From: [Justin Turnbull](#)
To: [Rachael Stevie \(CD\)](#)
Cc: ["Mike Merritt"](#)
Subject: FW: Mike Bach BLA
Date: Thursday, February 17, 2022 1:56:30 PM
Attachments: [image001.png](#)
[MIKE BACH 02-16-2022.pdf](#)

From: Justin Turnbull <justin.turnbull@co.kittitas.wa.us>
Sent: Tuesday, February 15, 2022 10:56 AM
To: Mike Merritt <mmerritt@obuncoengineering.com>
Cc: Rachael Stevie (CD) <rachael.stevie.cd@co.kittitas.wa.us>
Subject: RE: Mike Bach BLA

JOB NO.:	N/A
DATE:	12/1/2021
DRAFTED BY:	LMR
CHECKED BY:	MRM
SCALE:	1" = 100'
	2 OF 2

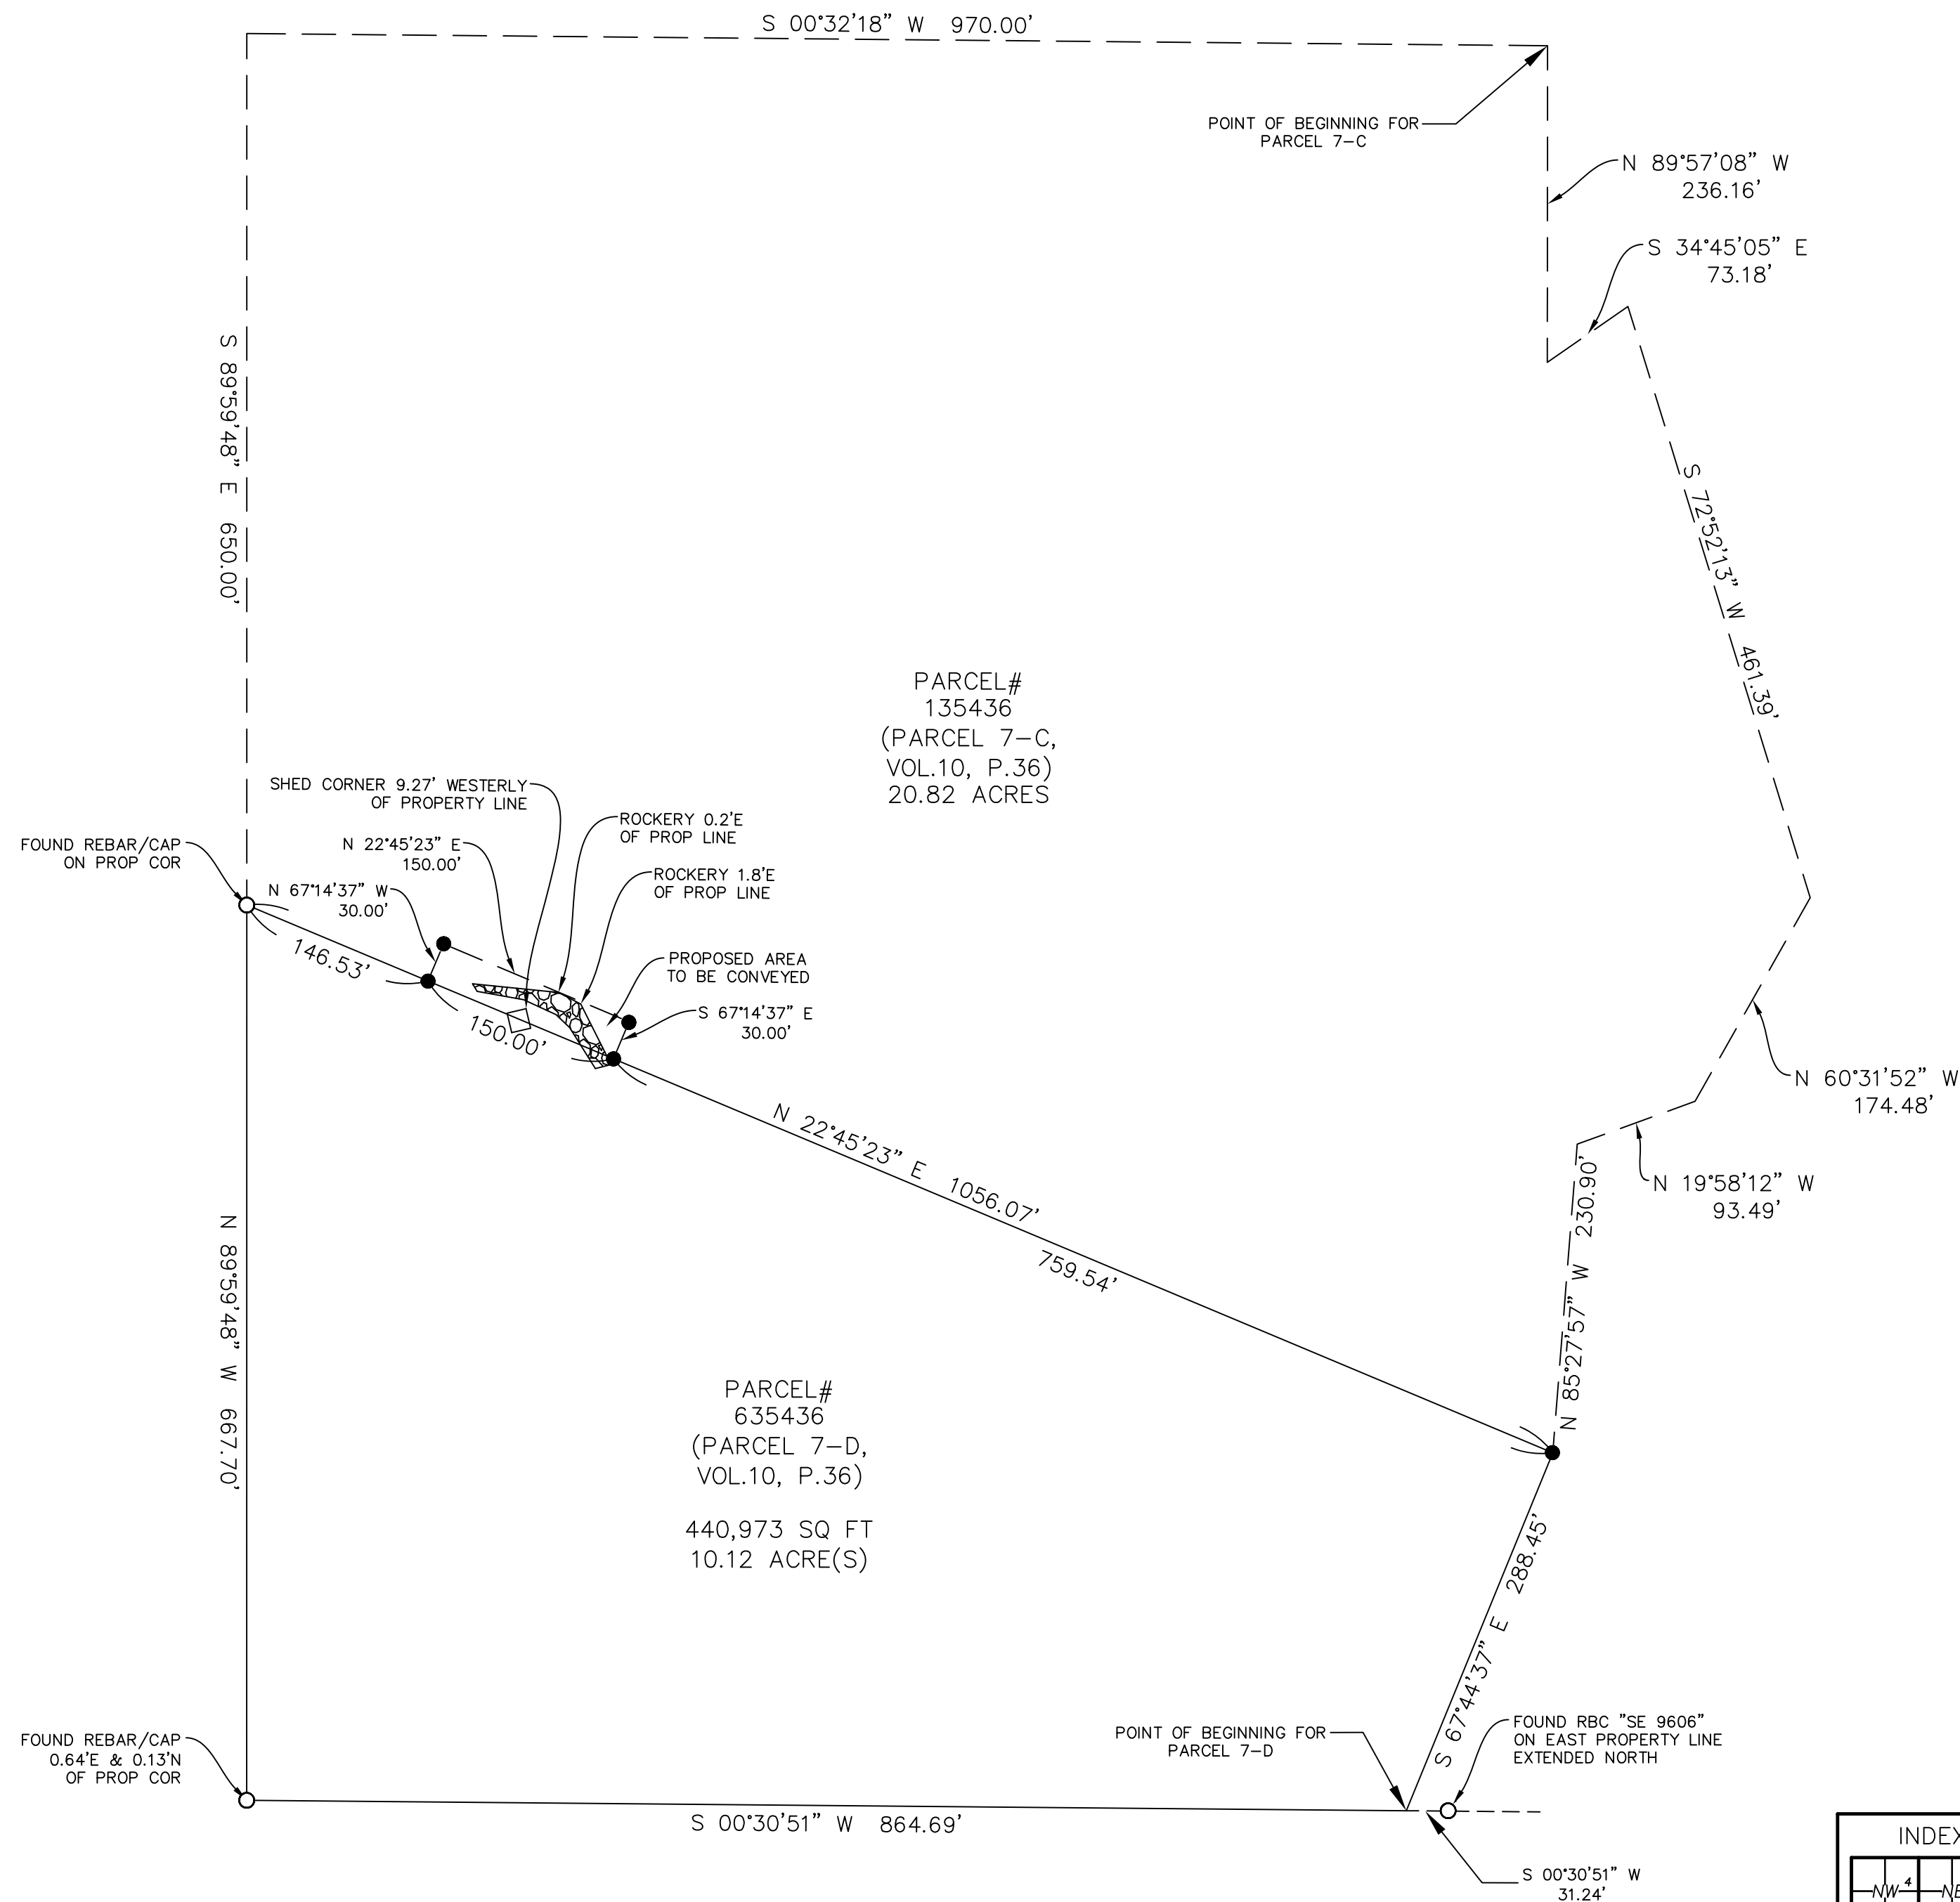
1. The entire new division line shall be staked in the field.
Please set property corners for the new division line, and show on the face of your survey.

2. The proposed survey fails to adequately show controlling survey evidence. Please include ties to controlling corners suitable for sensible retracement of the boundary line adjustment.
Of the three corners shown on the face of your survey, one is shown as being off, and one does not show distance ties. Please include enough suitable corners and/or information for subsequent surveyors to retrace your work.

I have addressed comments 1 thru 3 below.

3. The "Adjoiner" legal description does not match the text of the title report of record.
I have included the title report for your use. If there is a reason that the title report is incorrect, insufficient, or ambiguous, the title company can be notified and an updated title report can be prepared and resubmitted. If the title company is unwilling to make corrections, noting your description together with the title report description and why your description was needed would be a suitable option.

4. The legal descriptions are a mixture of basis of bearings. The original descriptions match the survey of record, while the transfer parcel matches the prepared map. Correcting the basis of bearing issues would resolve this, but alternatively, the record bearings could be provided on the face of the map in brackets "(XXX.XX)" and referenced on the legend.
This has been addressed on the most recent map dated 12/01/2021. No changes needed.

5. The line "Thence S00°30'51"W, 864.69" within the Bach Legal description is missing from the title report. The title company can be informed, and generate an updated title OR, if they are unwilling to do so, the discrepancy can be noted and the source of the missing data (Survey:10-36) provided.
